**Our Case Number:** ABP-316119-23

**Re:** DART+ South West Electrified Heavy Railway Order - Hazelhatch & Celbridge Station to Heuston Station, and Hesuton Station to Glasnevin  
County Dublin and County Kildare

Our Ref: **SID-ABP-2023-009**

**Proposed Strategic Infrastructure Development (SID): Railway Order application for a Railway Order for the DART+ South West Electrified Heavy Railway Order 2023. Subject to approval, the Railway Order will authorise CIÉ to carry out railway works and all works necessary to enable the construction, operation, maintenance and improvement from Hazelhatch and Celbridge Station (County Kildare) to Heuston Station Dublin (circa 16km) on the Cork Mainline.**

Figure 5-127 Heuston West Station Attenuation Tank Layout

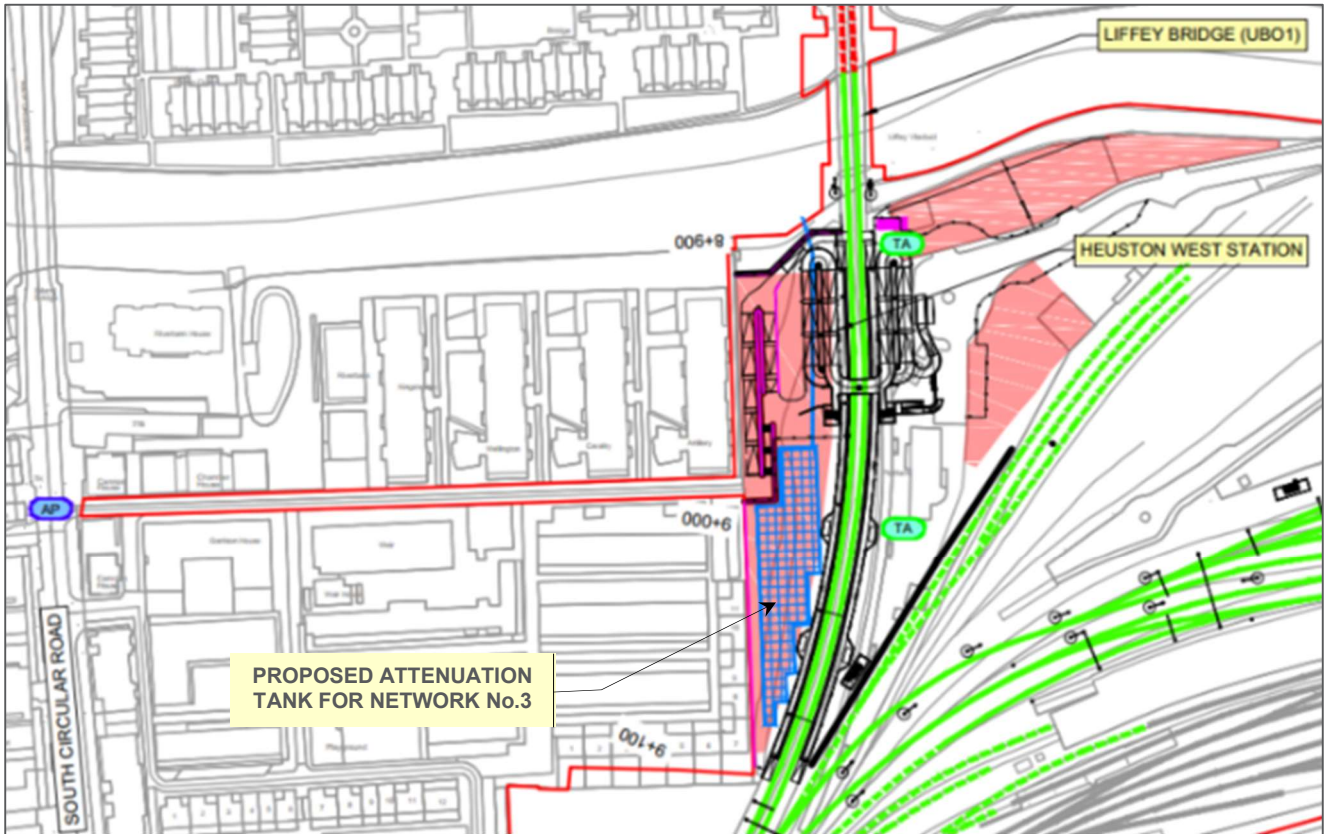
However the Department notes from the documentation supporting the present application that it appears that no oil separators or other filtration devices are to be installed on the inflows to the attenuation tanks which are to be constructed in Inchicore and Heuston Station and which will then outfall to the Liffey as part of the new drainage system serving the DART+ South West project. Similarly though the Phoenix Park Tunnel drainage system is to be modernised as part of DART+ South West, no oil separator or other filtration device is proposed to be installed on the system's outfall to the Liffey which is to be retained in its present format. The Department considers that on the precautionary principle oil interceptors or other filtration devices should be installed on the above mentioned drainage systems out-falling to the Liffey so as to avoid any increased contamination of runoff with hydrocarbons during the operational phase of DART+ South West due to the planned higher number of train movements it is to cater for. Such an approach should assist in maintaining water quality in the Liffey to sustain all the biota living in or dependent on it including SCI species, and also river lamprey, salmon, and otter which are species included in Annex I of the Habitats Directive (92/43/EEC).
